**From:** [Emily Fuhrer](#)  
**To:** [Rachael Stevie \(CD\)](#)  
**Subject:** Re: VA-20-00007 Fuhrer - Transmittal of Comments  
**Date:** Wednesday, September 30, 2020 11:32:38 AM  
**Attachments:** [image001.png](#)

Subject: VA-20-00007, Fuhrer Setback Variance SR 906 MP 1.78 right

SITE PLAN 1/2" = 6'

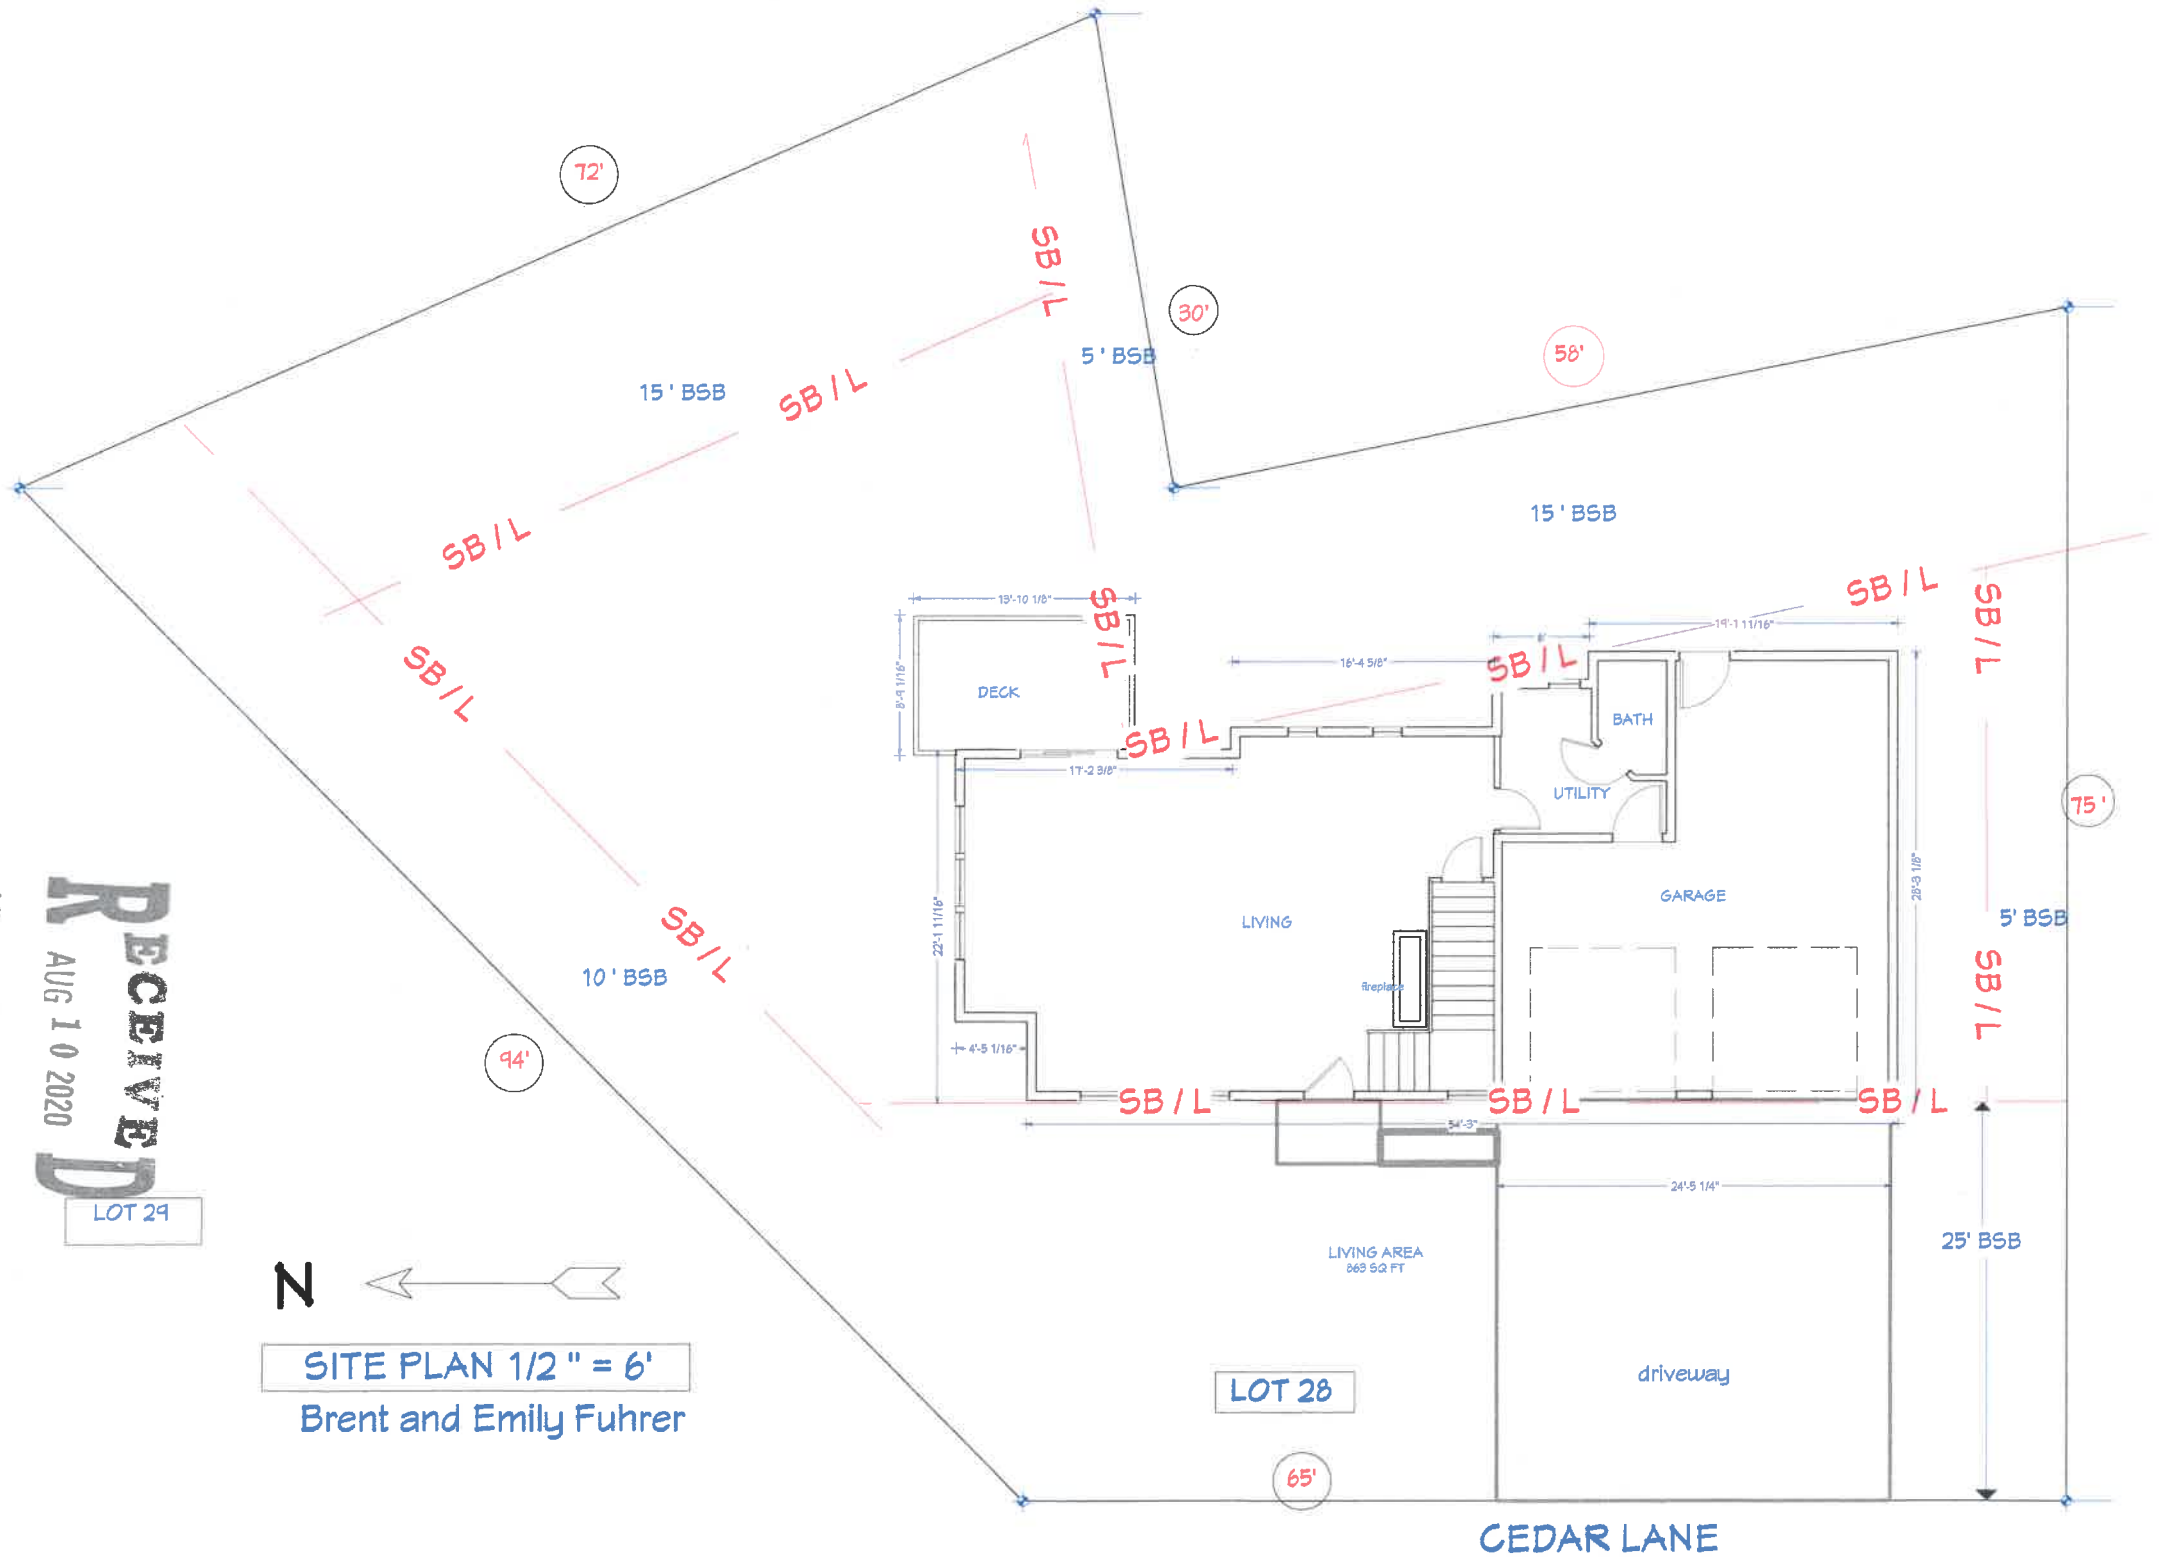
- In response to WSDOT's first concern, our variance is not asking for direct access to the freeway/ SR 906 which borders our property. We are simply asking for a decrease in setback feet. In fact part of the property line will still have almost 25 feet in one part of the back lot line since our lot is a "L" shape.

- In response to WSDOT's second concern, we have identified a few areas for snow storage/ accumulation on our property fully understanding the large volumes of snow that will come. The back part of our lot that borders SR 906 is a steep incline and we will not be accessing that part of the property at any time. They may push as much snow as needed off the freeway and we will not be pushing any amount in the direction of the freeway. We have purposely designed the roof line of our house for snow loads to fall off the roof and land on the sides of our house (north and south I believe) and not the front or back. The back being the direction of the SR 906. There is a large gully to the north where most of the snow will accumulate from clearing our access road on Cedar Ln, roof runoff and such. The designated setbacks we are asking for will also allow for better snow management between our house and the neighbors as well.
